Our Ref: 16015 Bushfire Huntlee MOD 20 RFS RFI Response 2-09-2022
Via: email

RE: HUNTLEE STAGE 1 MOD 20 – RFS RFI RESPONSE

MJD Environmental have undertaken a review of the request for information issued by the NSW RFS (Ref DA20200904003225-S4.55-2 Dated 22 July 2022). In response to the matter raised in the services review we provide the following information for your consideration to enable the completion of your assessment.

HUNTLEE TOWN CENTRE, NORTH ROTHBURY - MOD 20
ATTACHMENT 4: REQUIRED APZ AND BAL (PBP 2019)

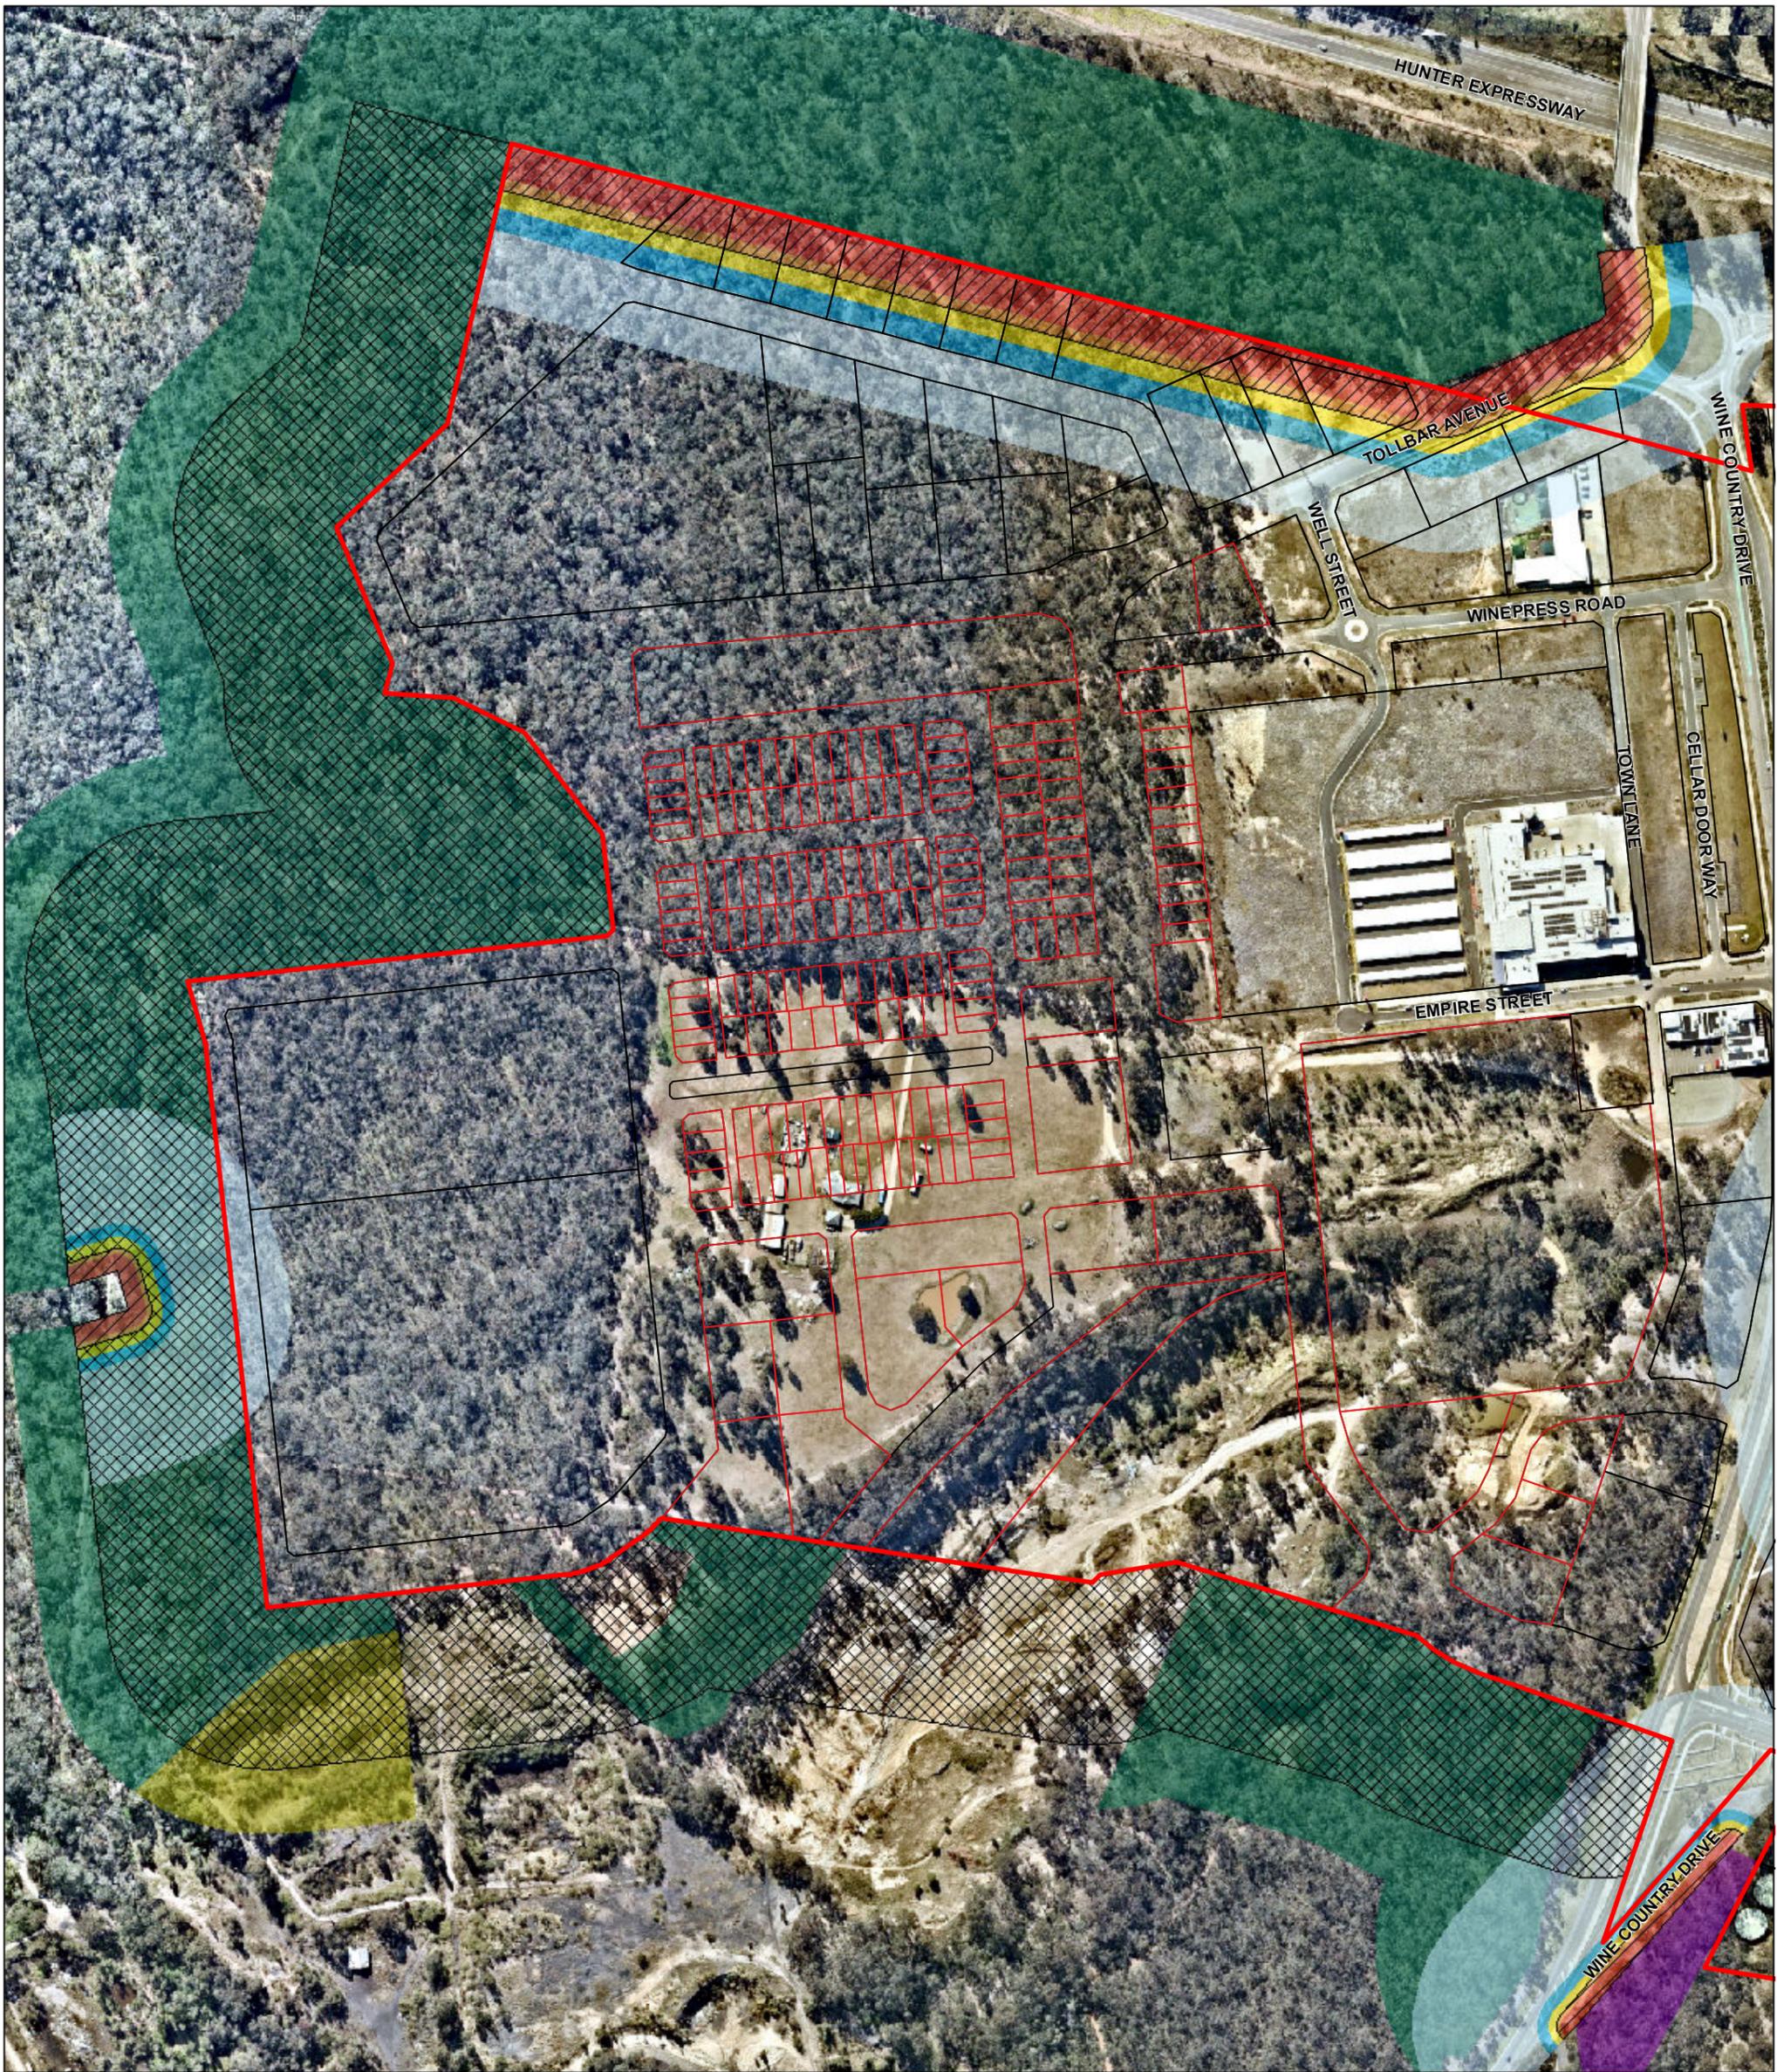
Item 2 - Areas identified by the bush fire consultant as Woodland, Grassland with scattered trees or Low Hazard vegetation must be demonstrated as complying against appendix 1 of Planning for Bush Fire Protection 2019. The woodland areas appear consistent with forests, grasslands with scattered trees appear to be woodland or open forests and the low hazard exemption does not appear to comply with A1.10 Low Threat Hazard Exclusions of Planning for Bush Fire Protection 2019.

Please refer to Item 1 response above, as stated in previous correspondence a contemporary APZ and BAL per PBP 2019 using vegetation classification and slope inputs approved by the RFS has been provided. It must be recognised that these inputs approved by the RFS underpin the existing and proposed development arrangement.

HUNTLEE STAGE 14 AND 15, NORTH ROTHBURY - MOD 20
ATTACHMENT 4: REQUIRED APZ AND BAL (PBP 2019)

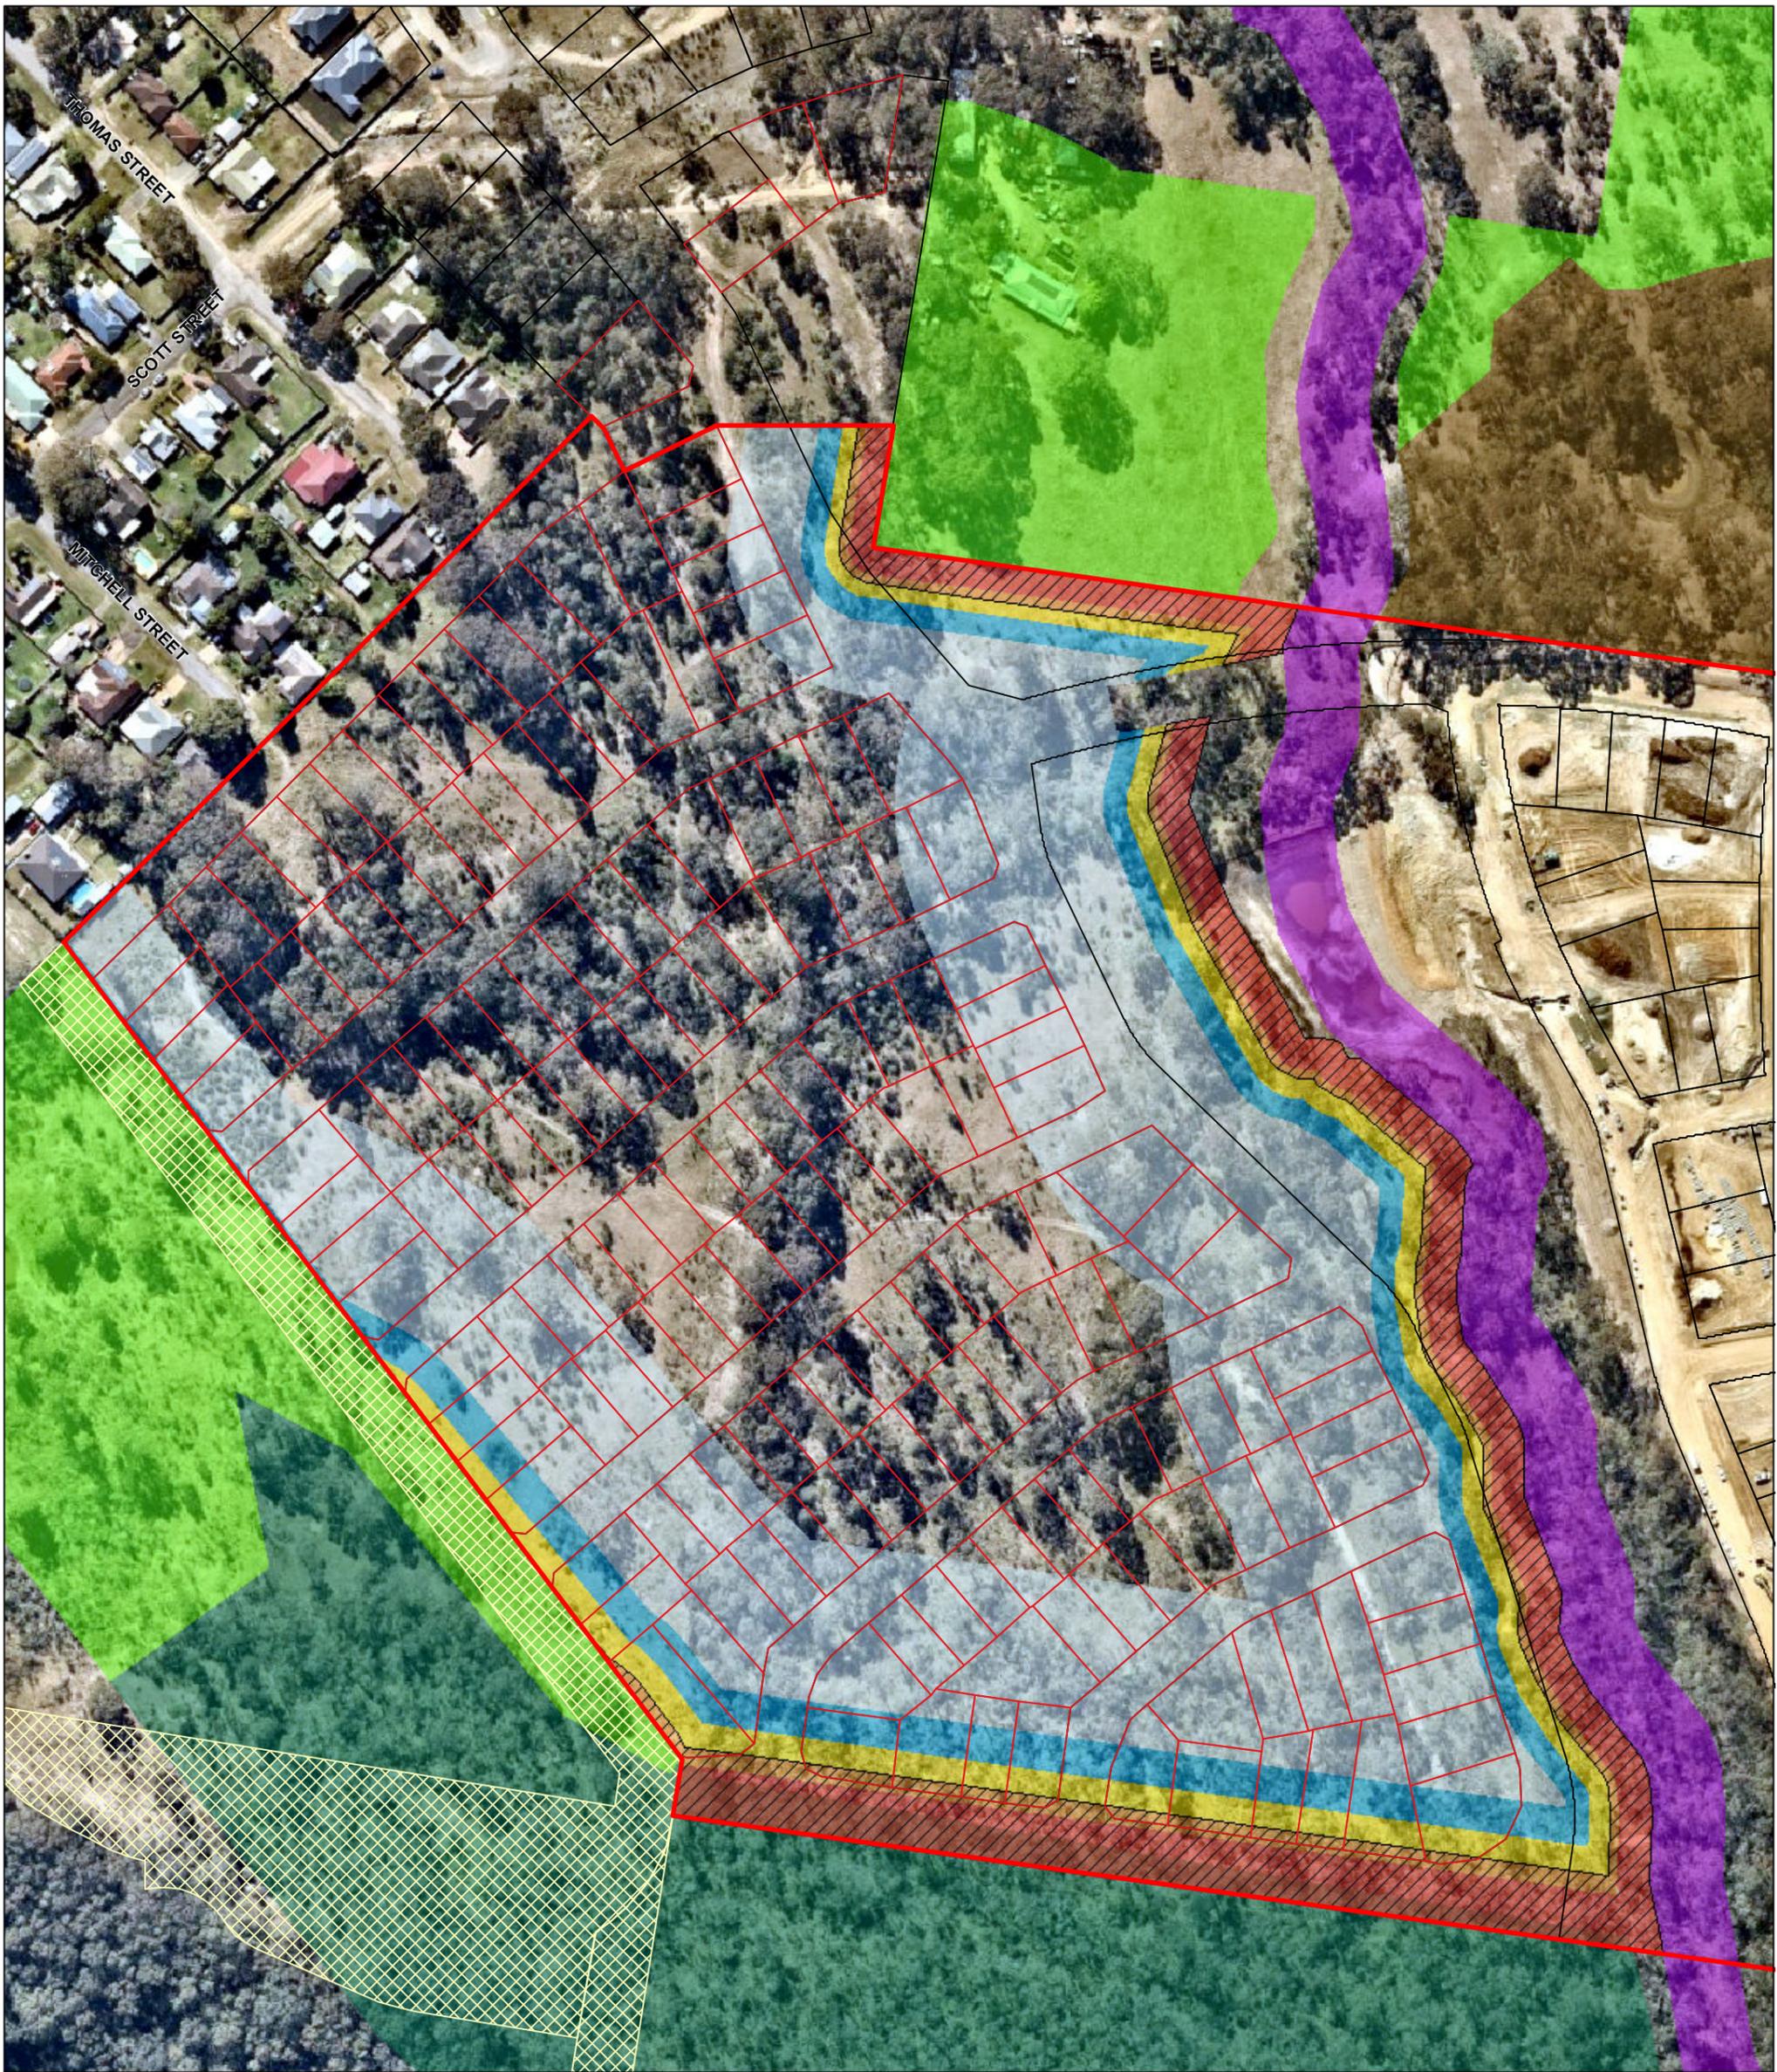
Item 4 - Demonstrate how the Reservoir and Access provides the proposed subdivision with a perimeter road and adequate APZs.

Perimeter roads must be provided between the proposed new subdivisions and the hazard.

Please refer to **Attachment 5** that provides the proposed modification instrument plans. Consistent with the development approach to Huntlee, generally perimeter roads will be established at the hazard interface.

Regarding the reservoir road, Rothbury Street will be formalised along the existing road reserve. The road to be constructed will be public and completed in the same fashion as all perimeter roads in the Huntlee development. Perimeter, collector and internal roads within sub stage 14-15 connect to this road and make connections through the existing North Rothbury village and into the existing Huntlee sub-stage 1 area.

The required APZ will be established within the road reserve and front building setback (where required). Refer to constraints on amended lots plan in **Attachment 5**.
